Reference: 21.615r03v02

Re: Project Francis – The Star
Response to Request for Information

We refer to the subject property and proposed residential development. TRAFFIX has been forwarded comments from Department of Planning and Environment concerning the Construction Traffic Management Plan.

Figure 3: Truck Route to and from Works Zones

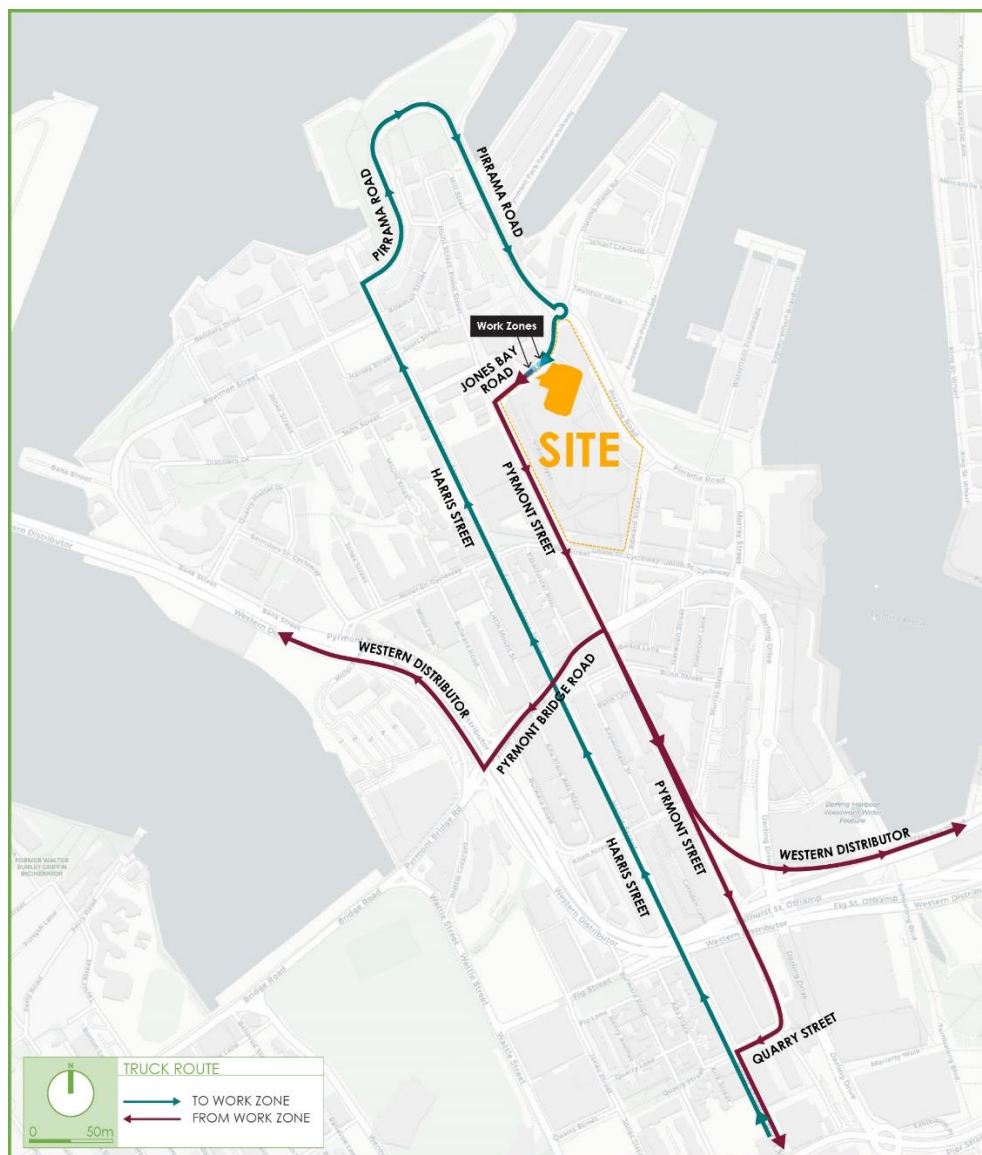
- *Haulage routes of large trucks moving and stopping on Jones Bay Road for extended periods of time are considered to significantly increase noise and air pollution. It is requested taxis be required to wait to be called elsewhere in the Star, rather than Jones Bay Road (during and after construction)."*

Trucks will be required to turn off their engine when stopped in the works zone to reduce noise and pollution impacts on the surrounding area. With regard to the taxi zone, as this is an existing arrangement it will continue to operate outside of the Works Zone operation during construction and will return to full operation once construction is complete. Any changes to the existing on-street parking arrangements, such as the taxi zone on Jones Bay Road, should be referred to Council as only they have the authority to change on-street parking arrangements.

Swept Path Analysis

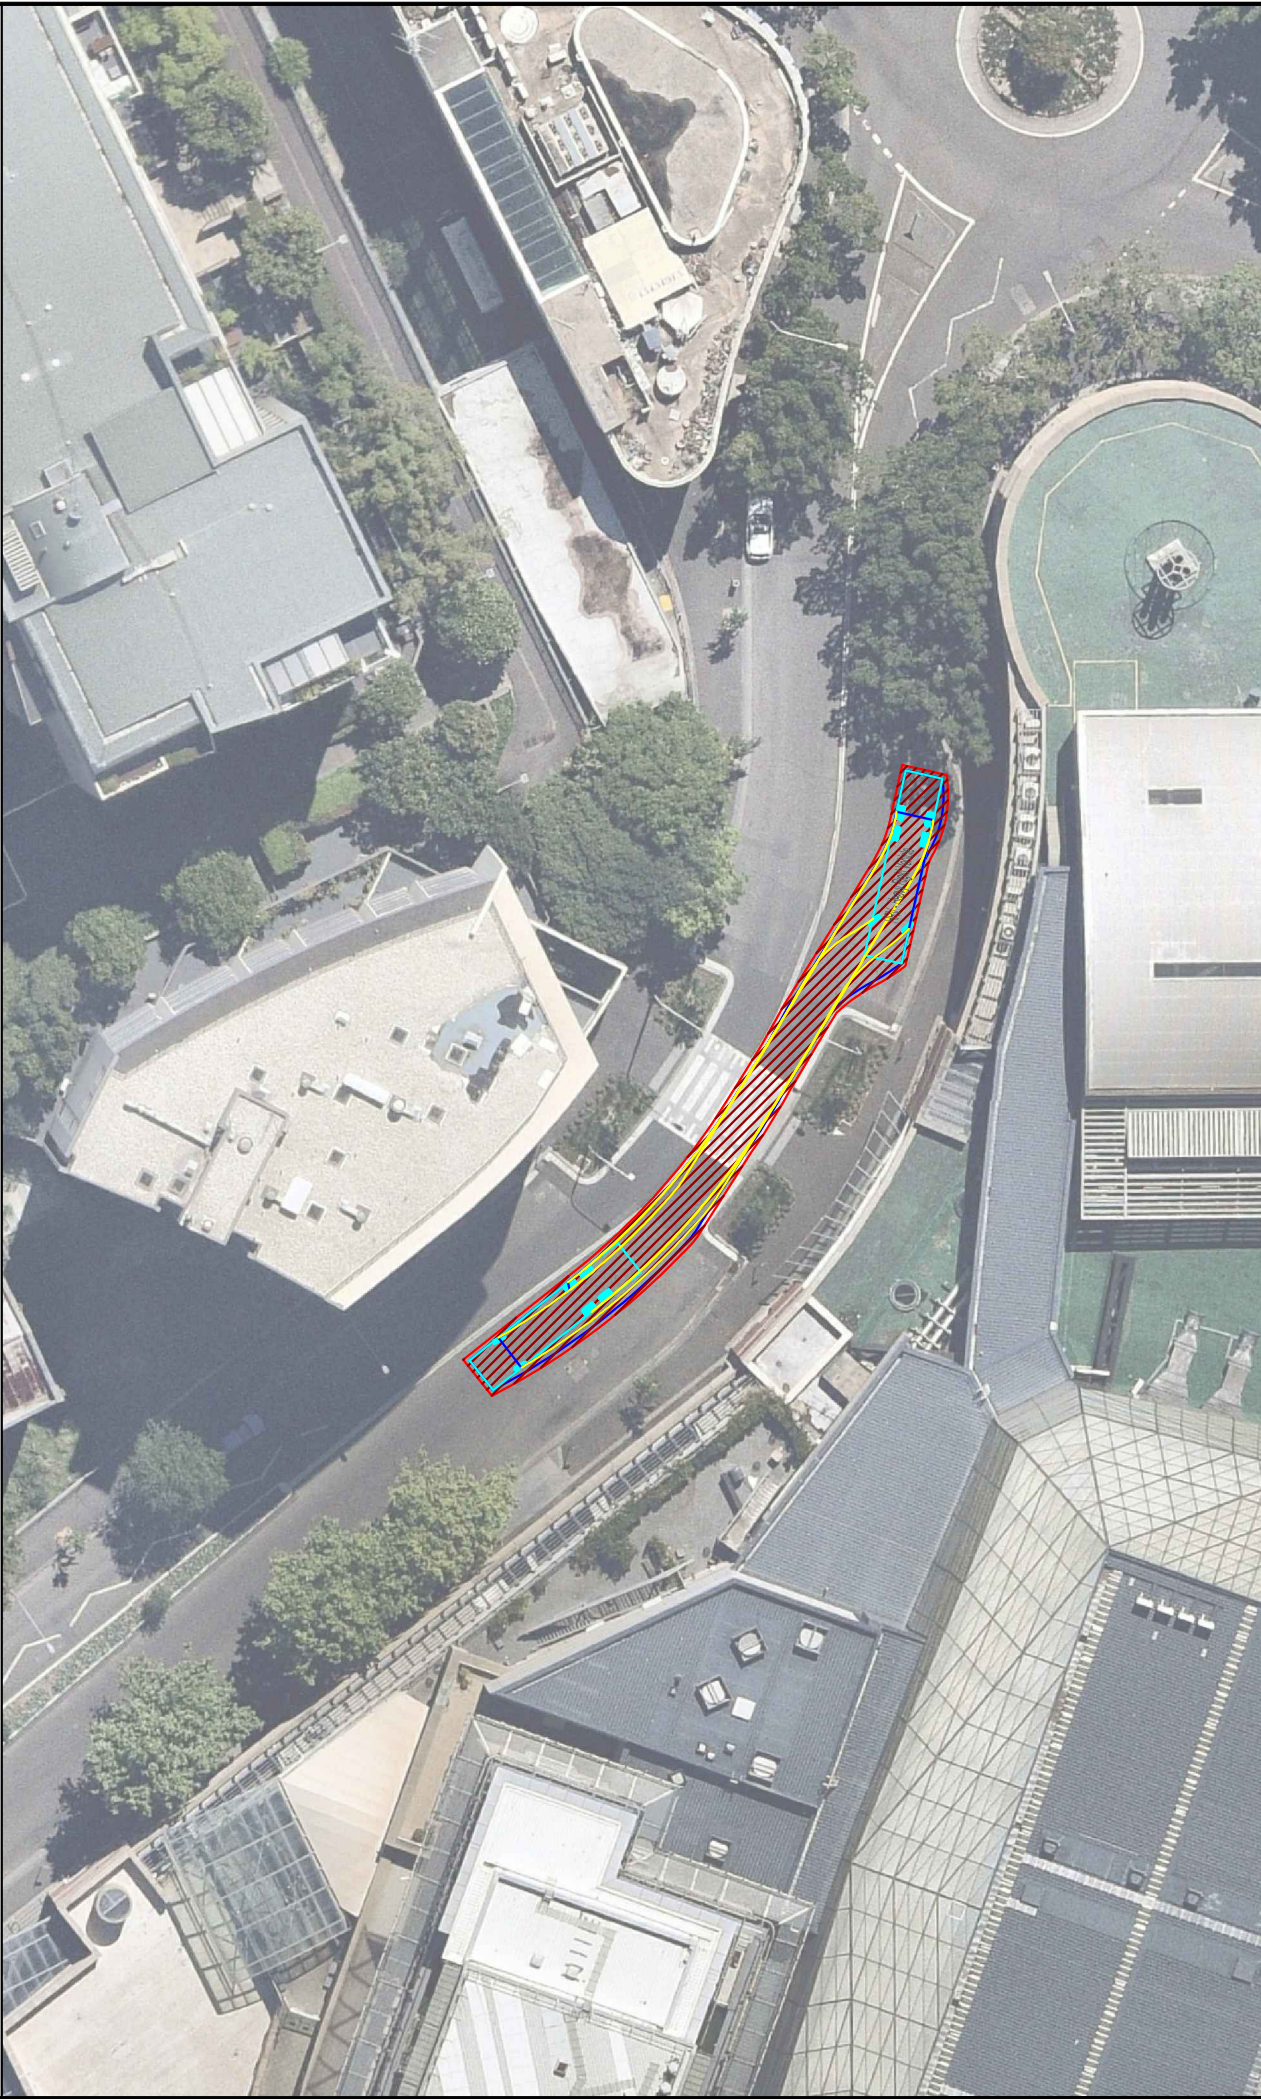
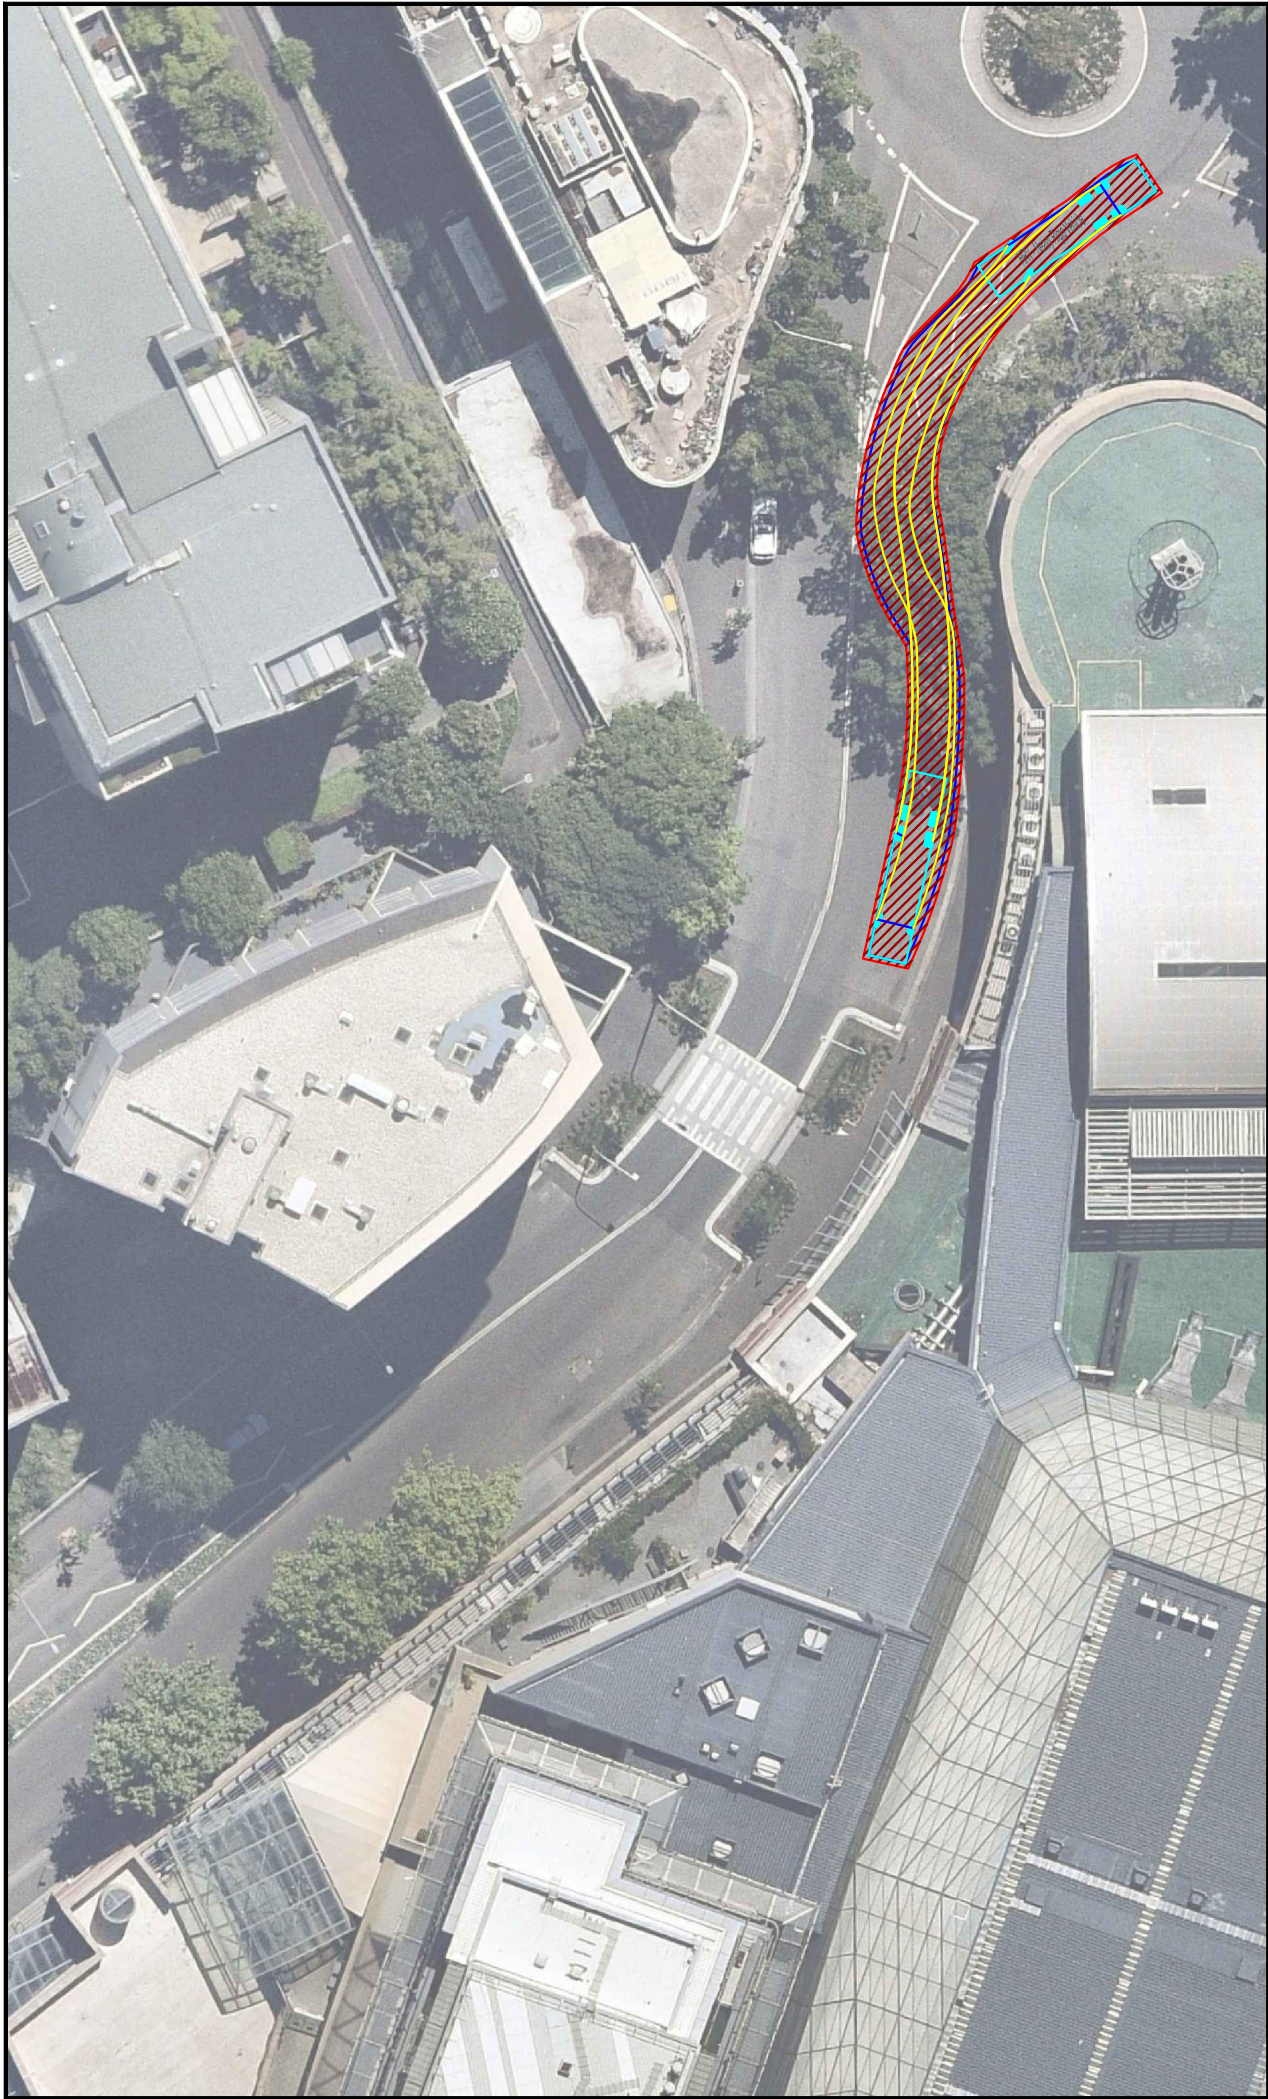
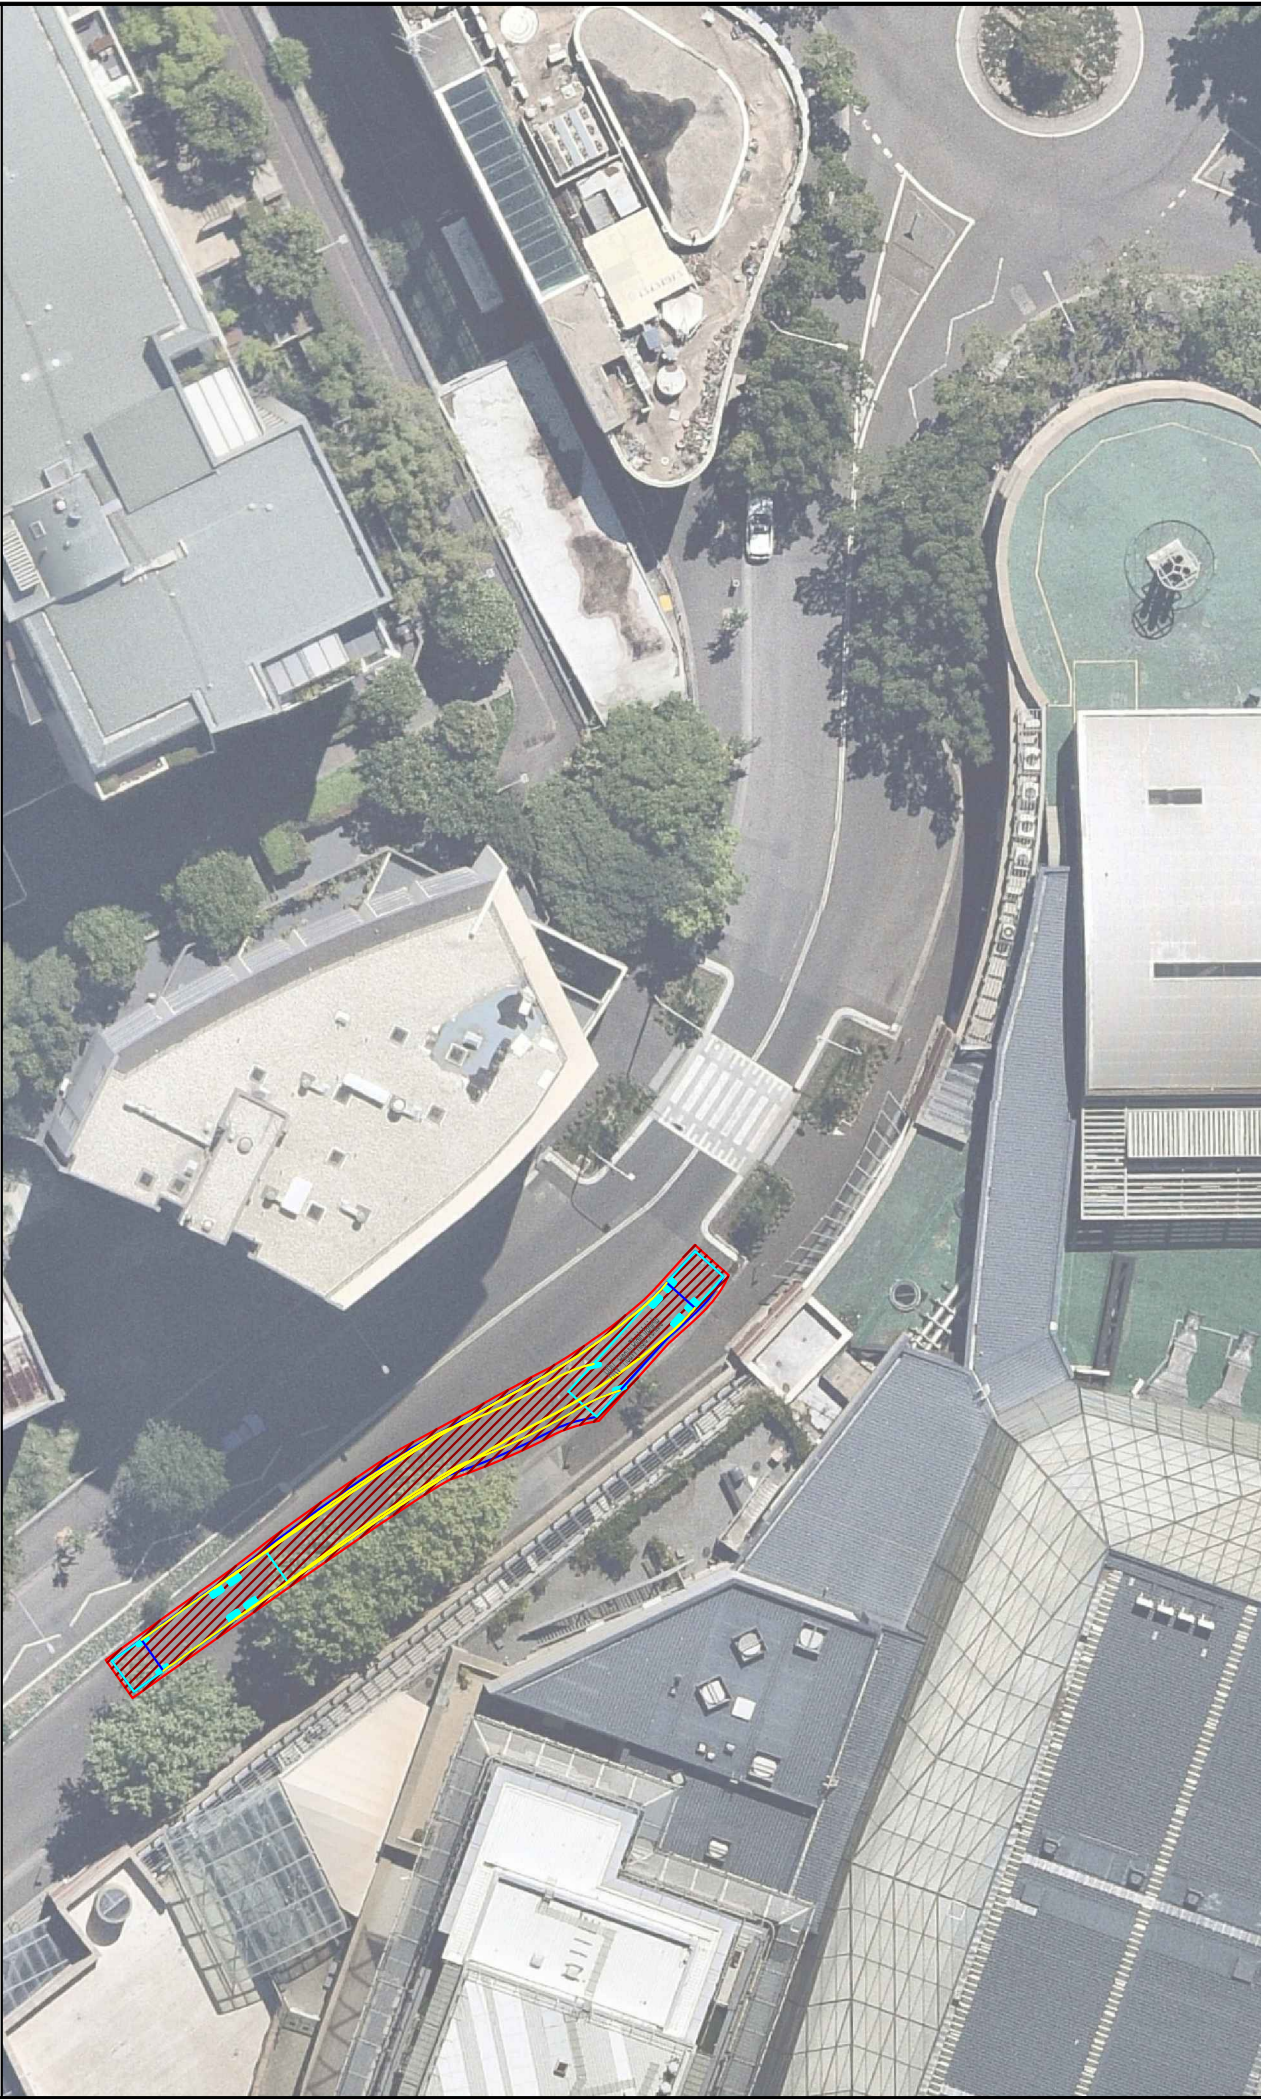
- Clarify how 20m articulated vehicles would be managed during construction and provide further swept path analysis from the proposed work zones to confirm they will not interfere with traffic on Jones Bay Road.

The 20m articulated vehicles (AVs) will be subject to individual applications to Council for access to the existing loading dock within The Star. This is to comply with Council's standard requirements as provided in Appendix A of the CTMP. As such the CTMP does not refer to the AVs as separate applications will be prepared for these movements with the relevant swept path analysis. It should also be noted that the AVs were not to access the works zone on Jones Bay Road and only the existing loading dock for The Star. Therefore, the CTMP is considered sufficient to address the majority of construction vehicles and the AVs will be subjected to separate applications to Council in accordance with their standard CTMP requirements.
